**Jeanie Bourke - Re: 1706 Forest Ave., BP#2015-01703 Amendment**

**From:** Jeanie Bourke  
**To:** Douglas Morin; Evan Carroll | Bild Architecture  
**Date:** 8/5/2015 8:33 AM  
**Subject:** Re: 1706 Forest Ave., BP#2015-01703 Amendment

11 **UTILITY RAMP DETAIL**  
SCALE: 1/2" = 1'-0"

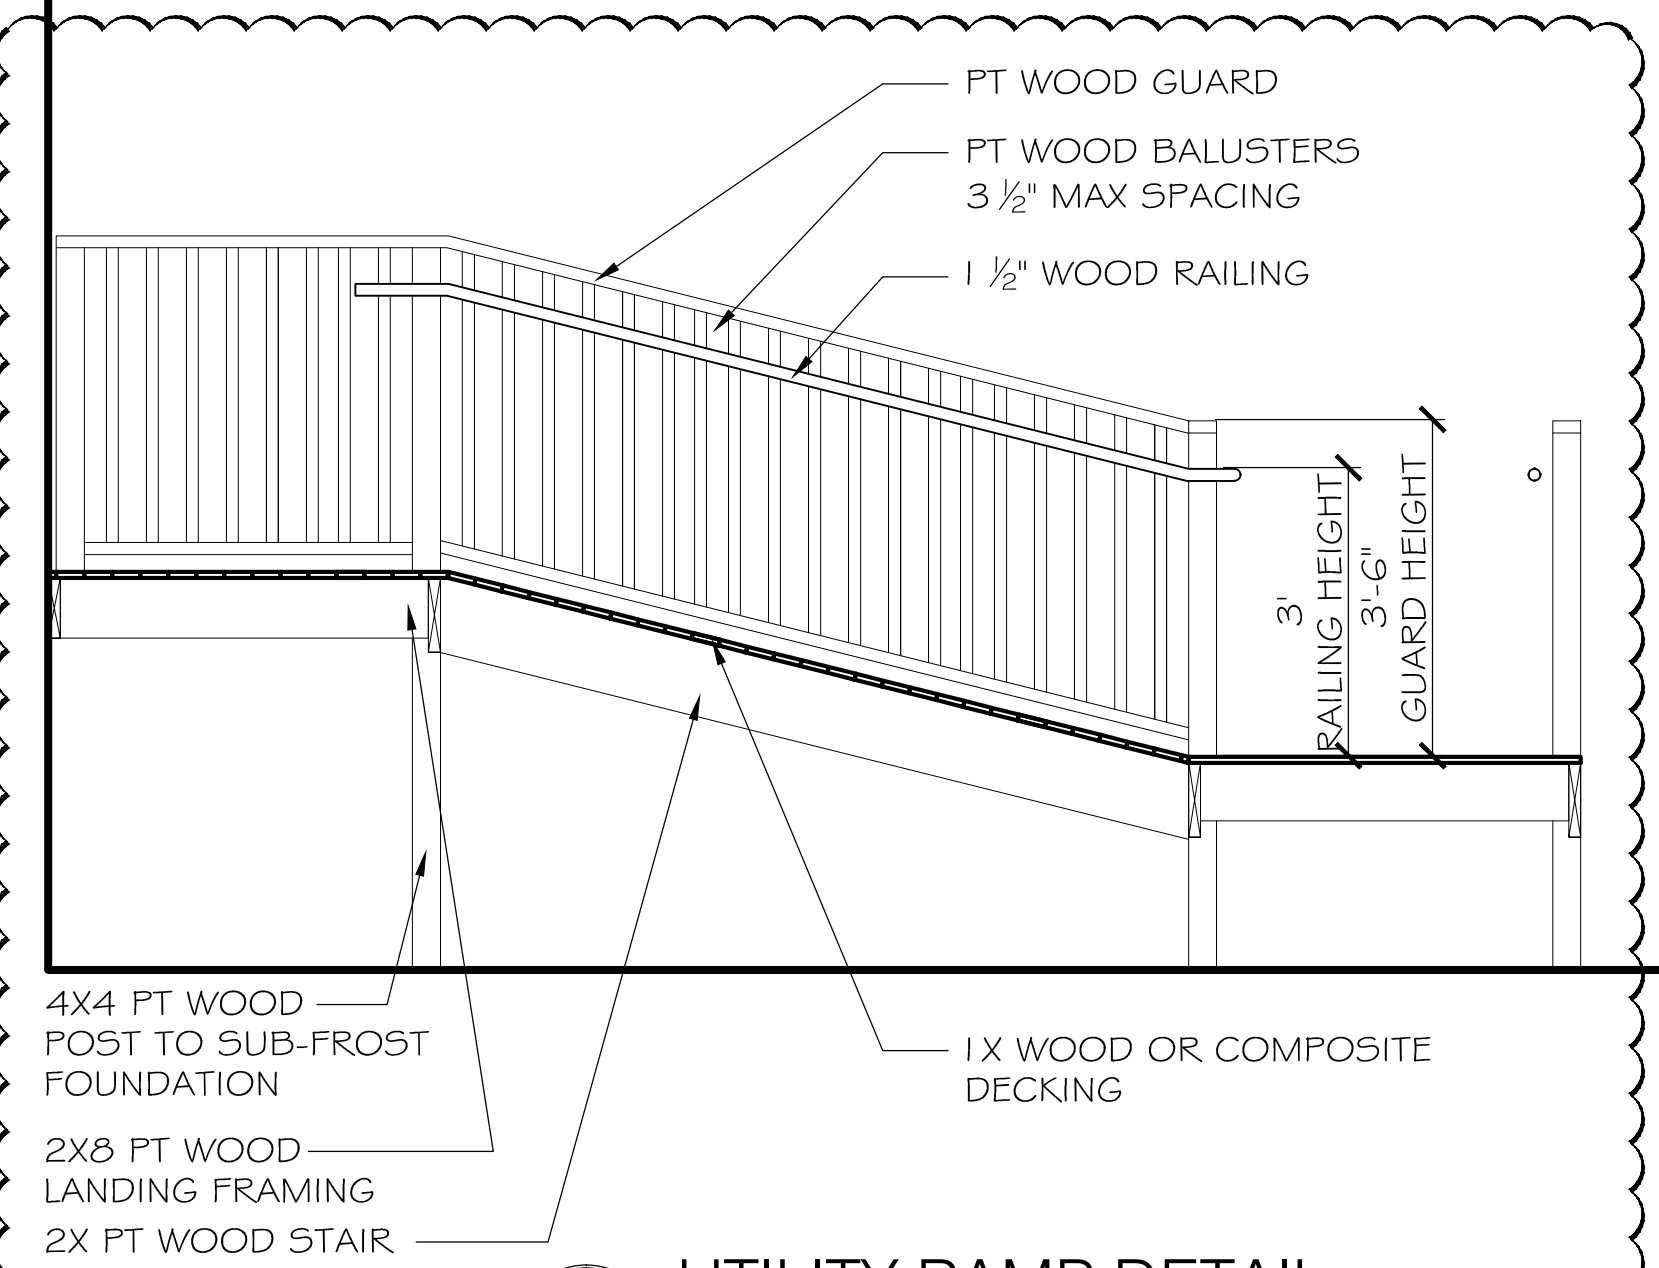
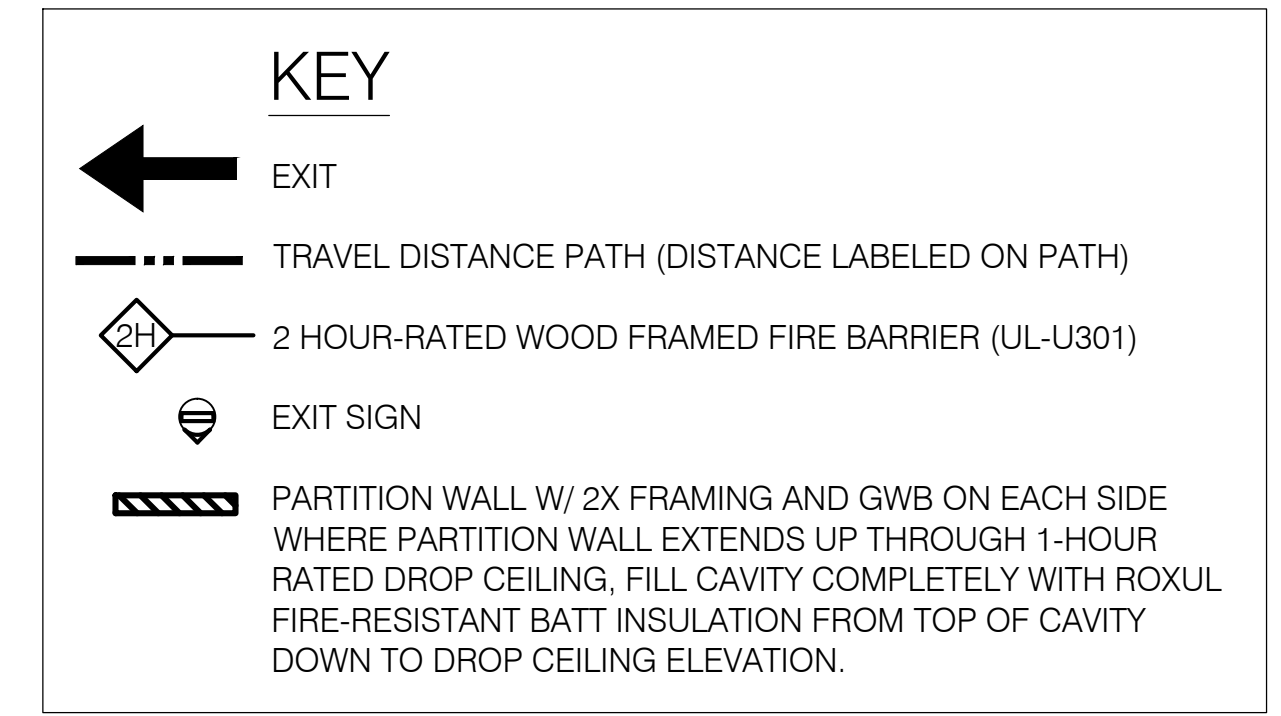
This discussion will also fold in the front entry ADA ramp that was removed in lieu of future site work approvals in order to establish a date for completion of this.

In reviewing the amendment to add a service ramp, it has come to my attention that the Administrative Authorization application for staff level site plan review has not been submitted. This is required for commercial properties that have additions of 500 SF or less, I don't recall if we discussed this at our meeting. See this link:

On the ADA ramp, our initial ramp design simply didn't work, so we have site in-feasibility. We would certainly add the ramp when site work is done, but don't think it appropriate to have a time constraint specifically for the ramp, which cannot be done with the current grading.
